M Reddington Response to SoS letter of 23_08_2024: ID20037459

Table 1: M Reddington Response to the SoS letter of 23 -08- 2024

Table 2: M Reddington Comments on Compensation Measures Tracked Changed TR020001-003475- LR (August 2024 version)

Figure A1.1: Indicative noise contour plan

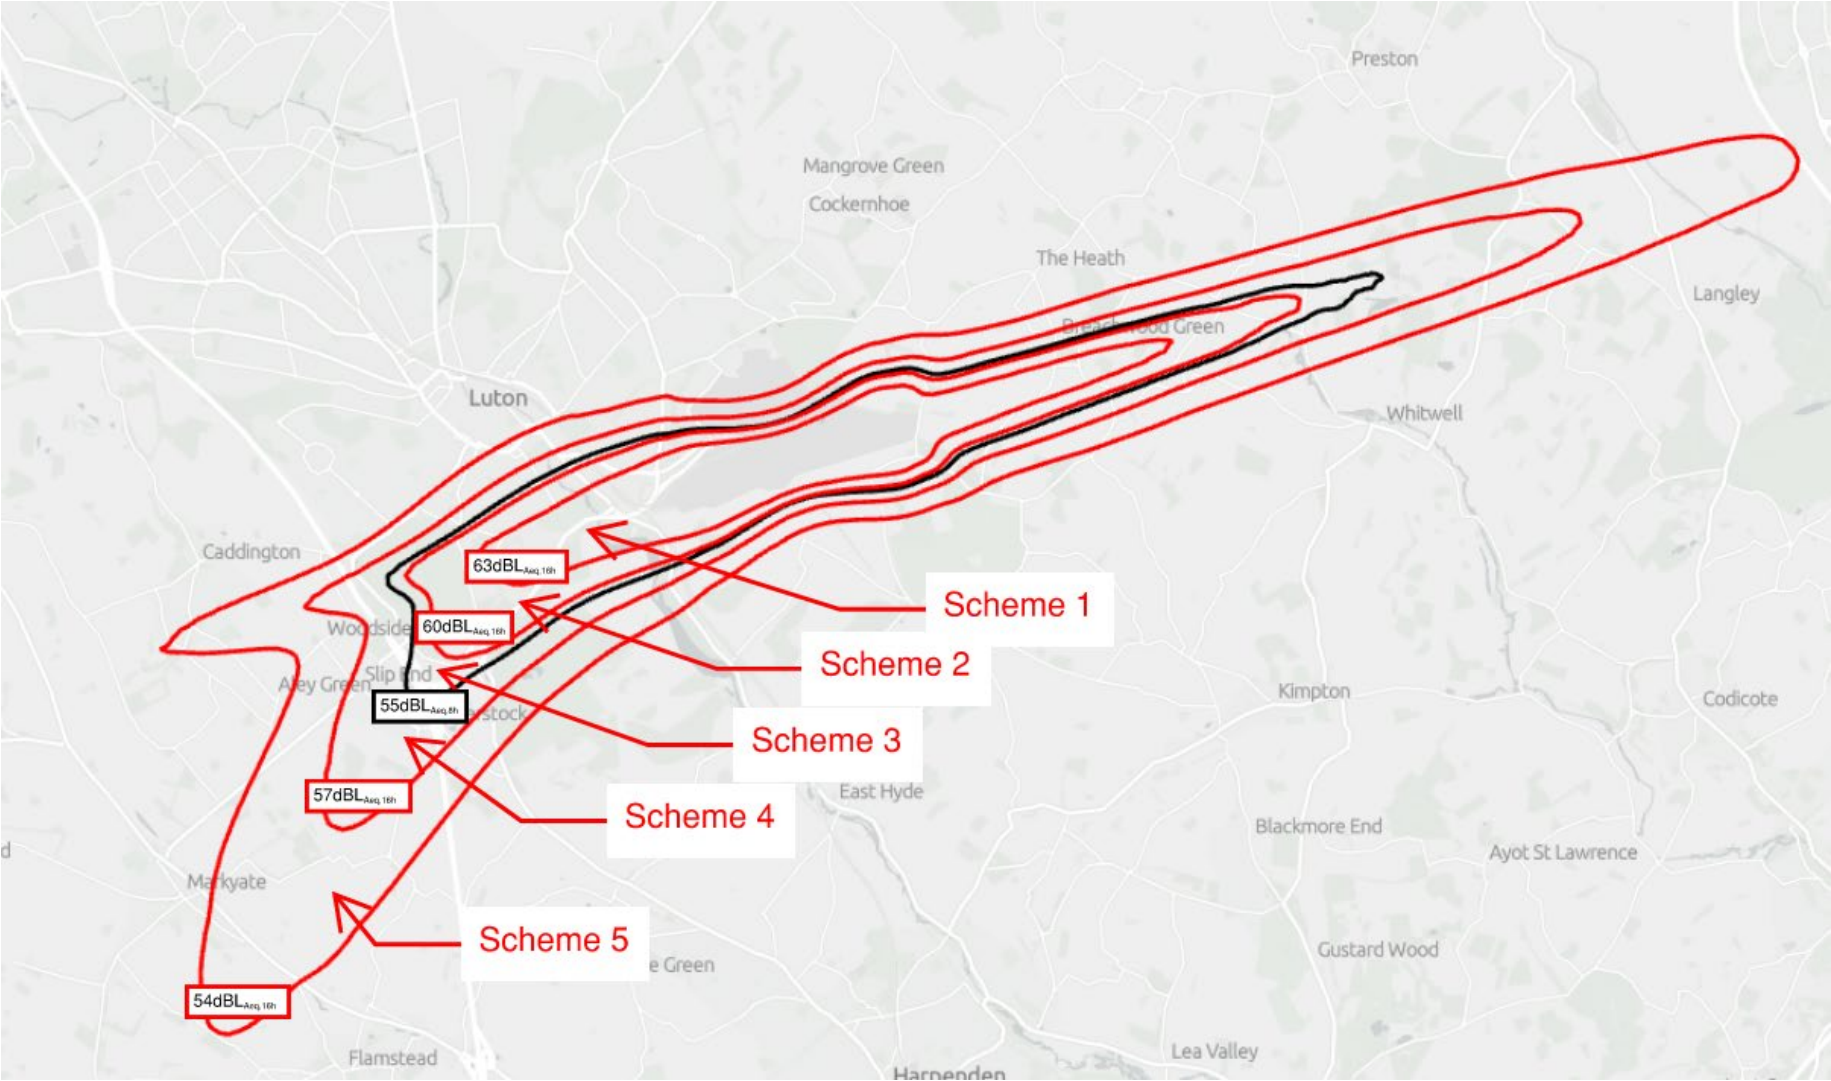
5	ID 5	Appendix A	<p>Indicative Air Noise contour drawings are included but there are none for Ground Noise – or Traffic Noise.</p>
6	ID6	Appendix C	<p>The Applicant has considered Public Buildings Noise Insulation Scheme and The Voluntary Acquisition and Hardship Schemes during the Examination and determined that what expenditure is anticipated will fall within the Funding Statement.</p> <p>However if there were to be more-than-anticipated demands the Applicant does not state how the monies will be funded.</p>
